LAND AT TORTINGTON, ARUNDEL

Response to Ecology Consultation

eg17809-EC-CR-REV00
08/02/21

Planning Ref: AB/135/20/OUT

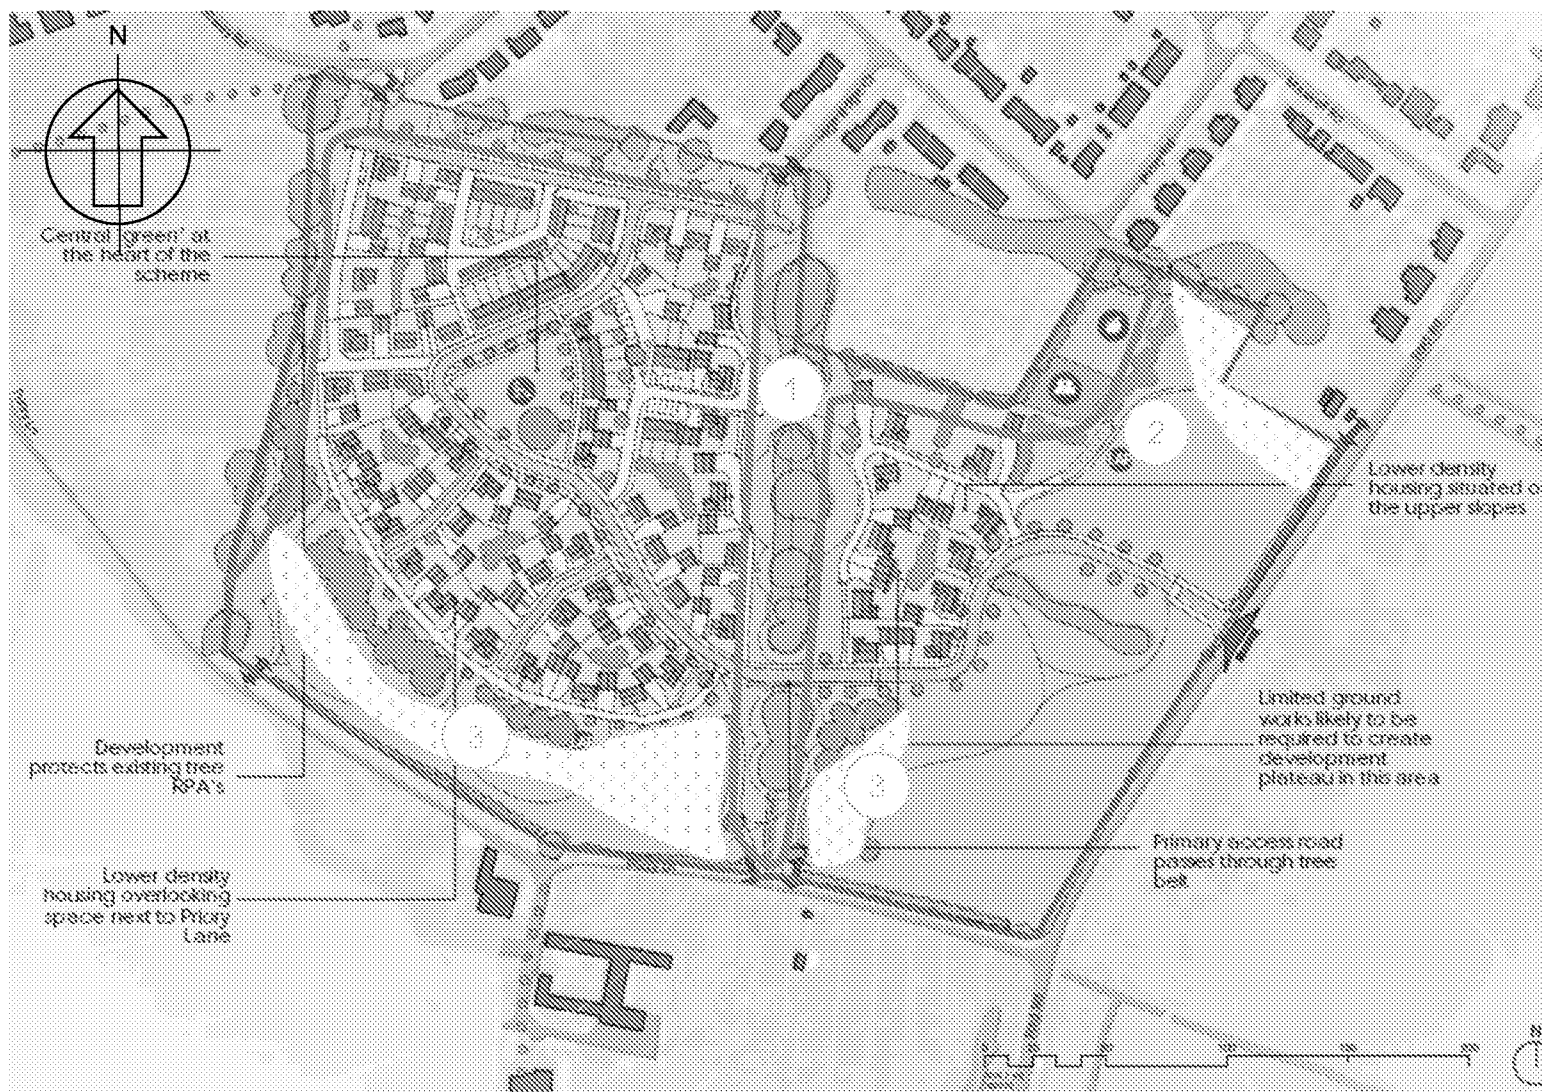
"The lighting scheme for the site will need to take into consideration the presence of bats in the local area and the scheme should minimise potential impacts to any bats using the trees, hedgerows and buildings through the provision of dark habitat orientated north-south direction and avoiding unnecessary artificial light spill through the use of directional light sources and shielding. We require that further details of the lighting scheme and dark corridors are provided as part of this application."

The ecological strategy in relation to bats is to maintain commuting and foraging corridors on key axes through and around the site. This is achieved by using a combination of lighting design measures including back-shields, low-level lighting on 4m columns and bollards, and directional fittings. The details of these are provided in the reports referred to above.

The dark corridors for bats are illustrated in the plan overleaf, overlaid onto the indicative lighting design drawing. With reference to the plan, these provide corridors of less than 1 Lux as follows:

1. A continuous dark corridor in a north-south direction along the eastern site boundary
2. A dark corridor in an east-west direction, along the site's northern edge, reach 2Lux in two places by turning heads
3. A dark corridor in a north-south direction, broken in one place by lighting of the adopted road;
4. A dark corridor in a north-south direction along Ford Road, partially affected by lighting of the adopted road.

There are therefore three north-south links, one across the top of the site and potential for an improved link across the bottom edge of the site (not shown on this figure).
